MMC congress building

Jeff Tarling <jst@portlandmaine.gov>

Thu, Oct 11, 2018 at 1:05 PM

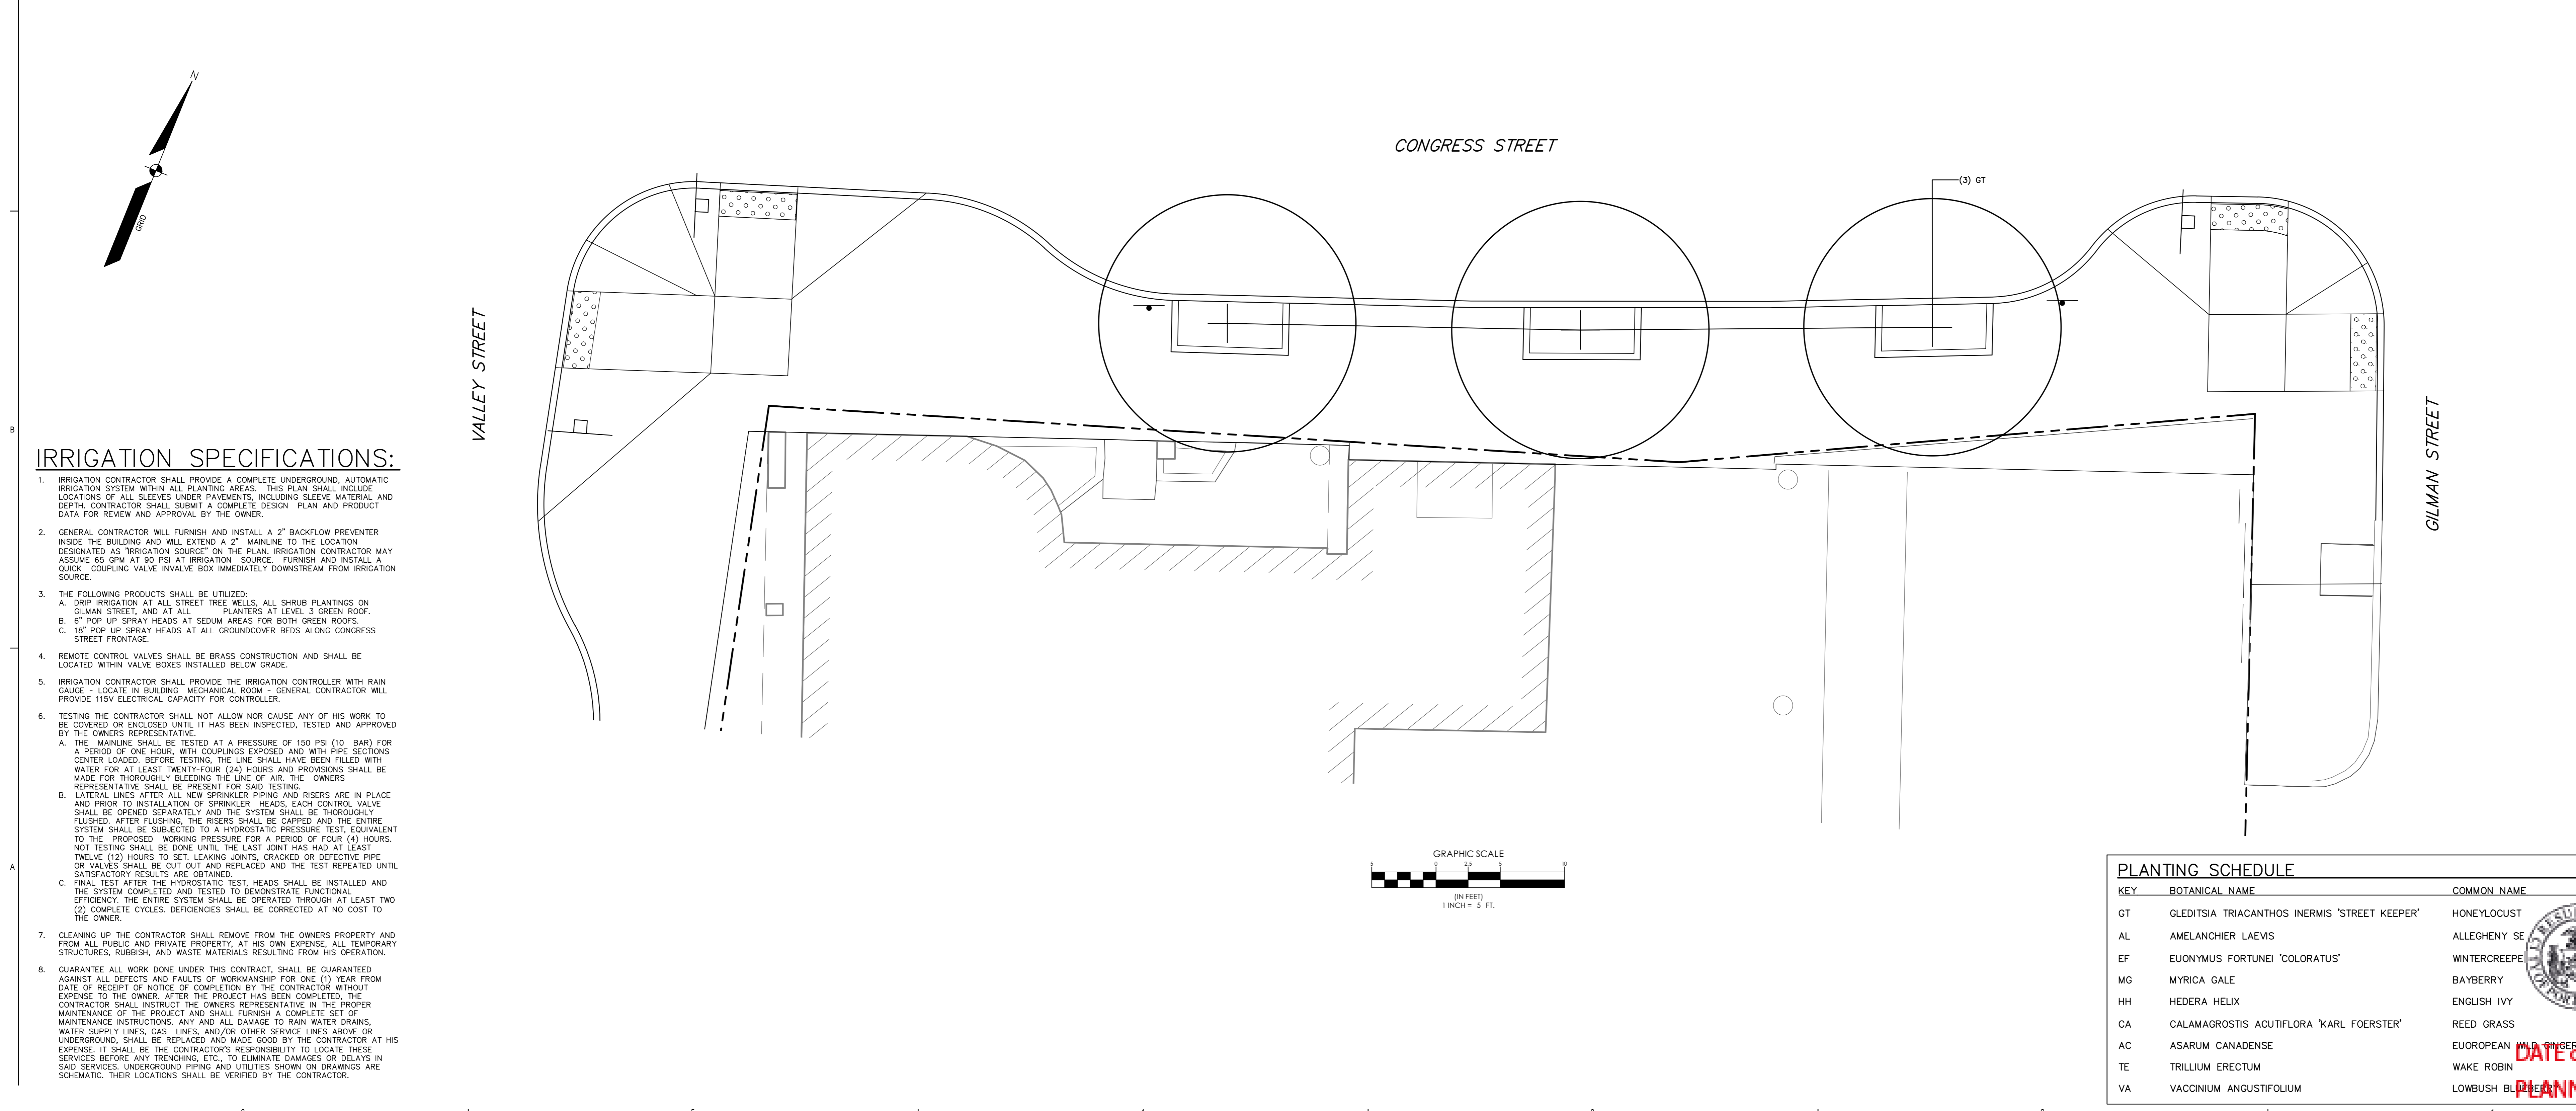
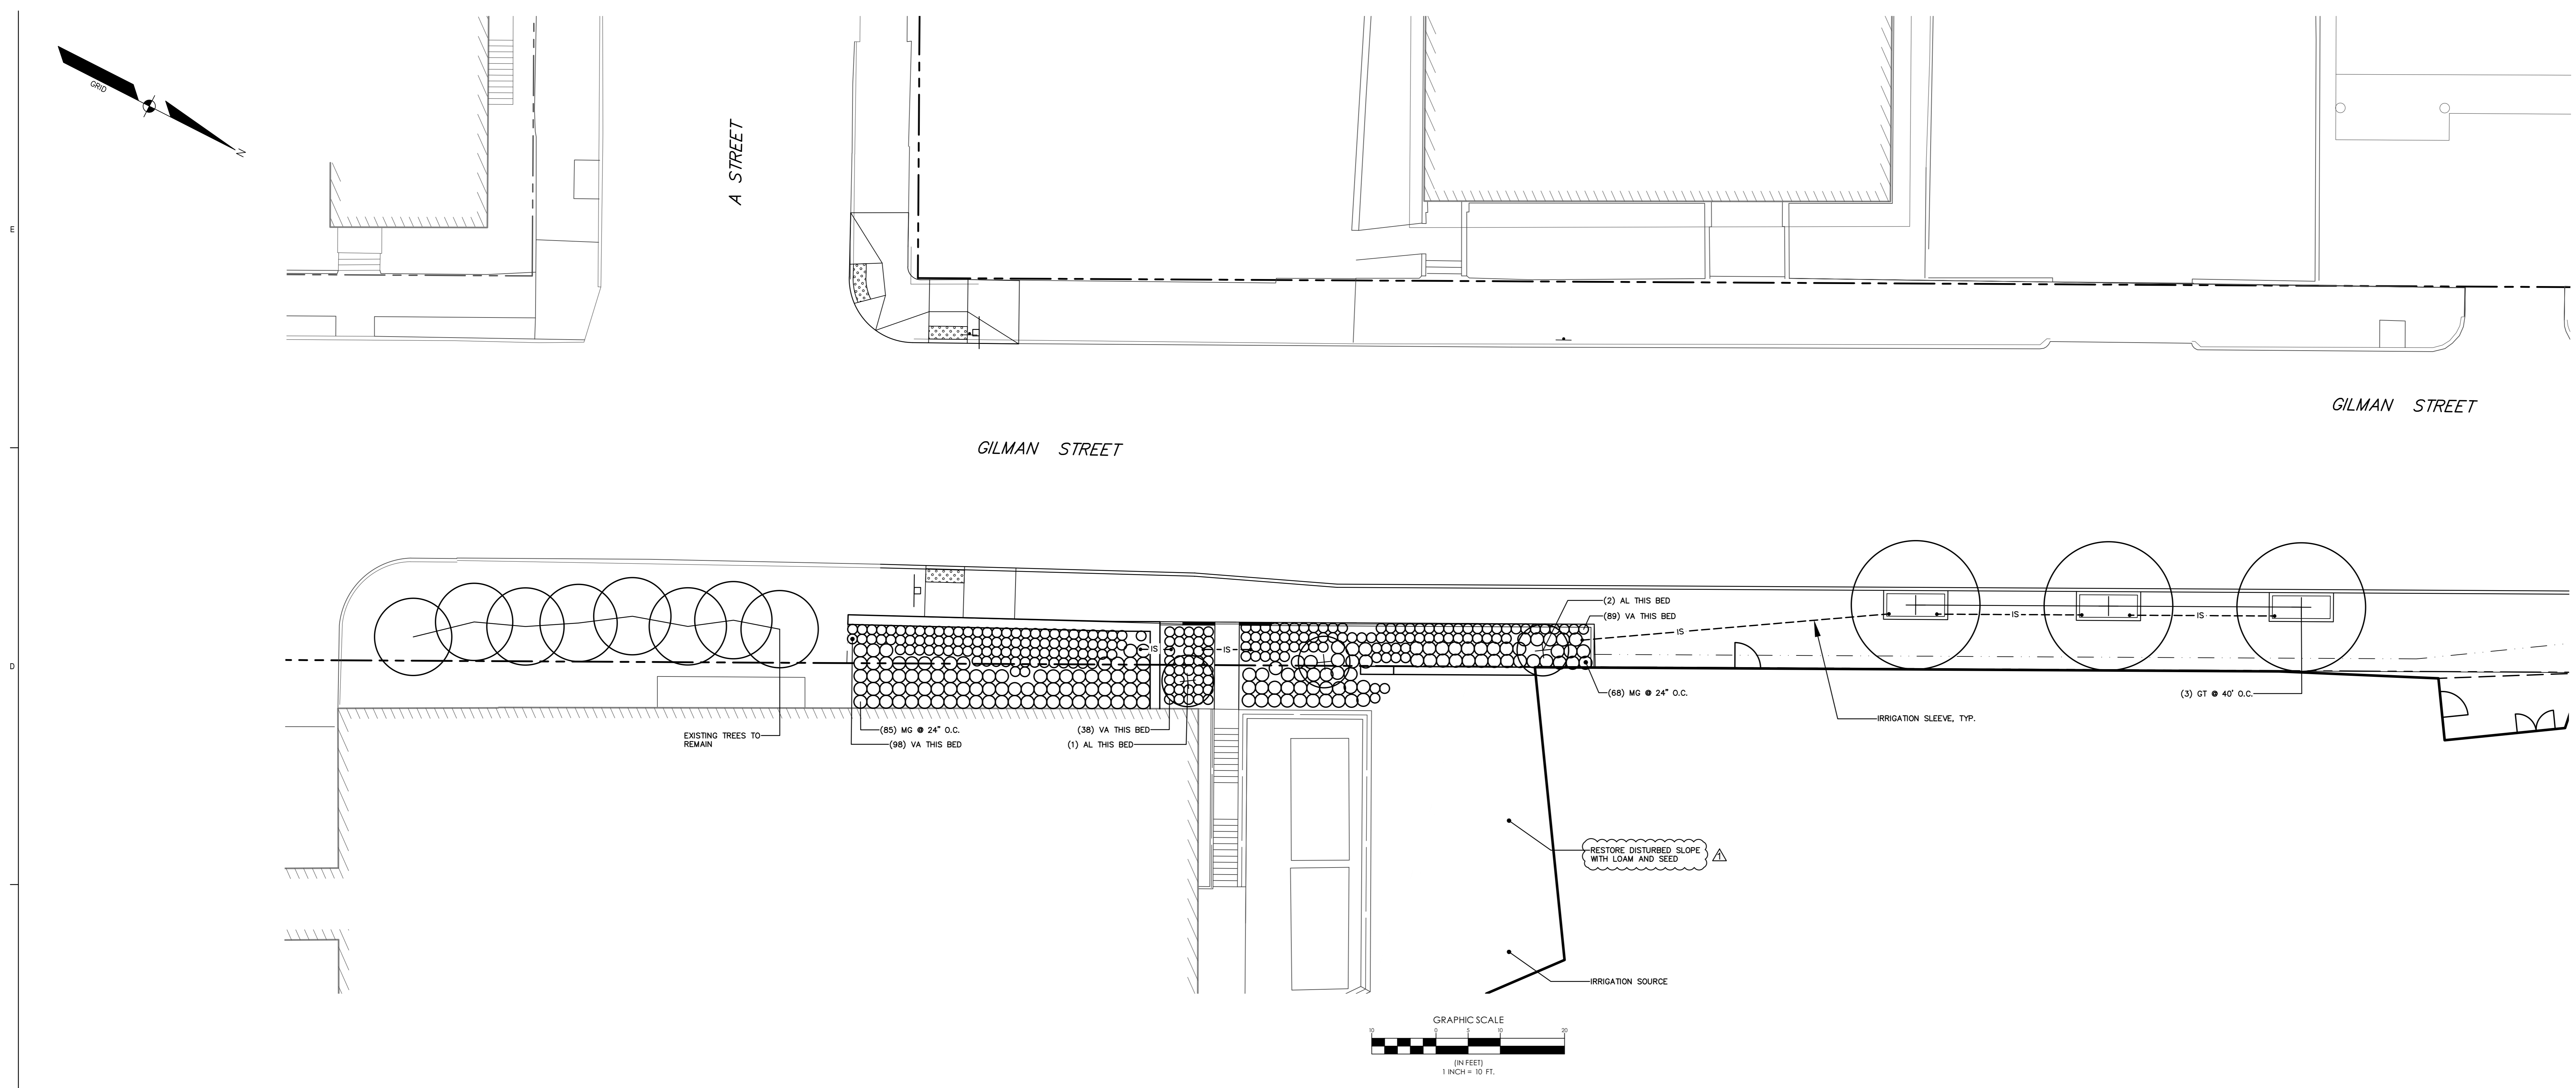
We would like to see the planters both the tree planters and the proposed long planters have rounded edges or (radius) corners. These are visually more appealing and seem to work better for winter snow and ice clearing. Our spec (see attached) recommends the curbing with a 'thermal finish' which unlike the polished regular street curb looks better and is more tactile for walking and less skate board friendly, if that matters.

On special projects like this it would be good to encourage the applicant to go with beefier granite on the planters than the standard 5" width. We noticed both Portsmouth and Boston have used 6" + and for the larger planter it could use used as a seat wall if appropriate. Included the pics of the rain planter from unknown city as it could serve a purpose as a functional stormwater feature and design concept idea.
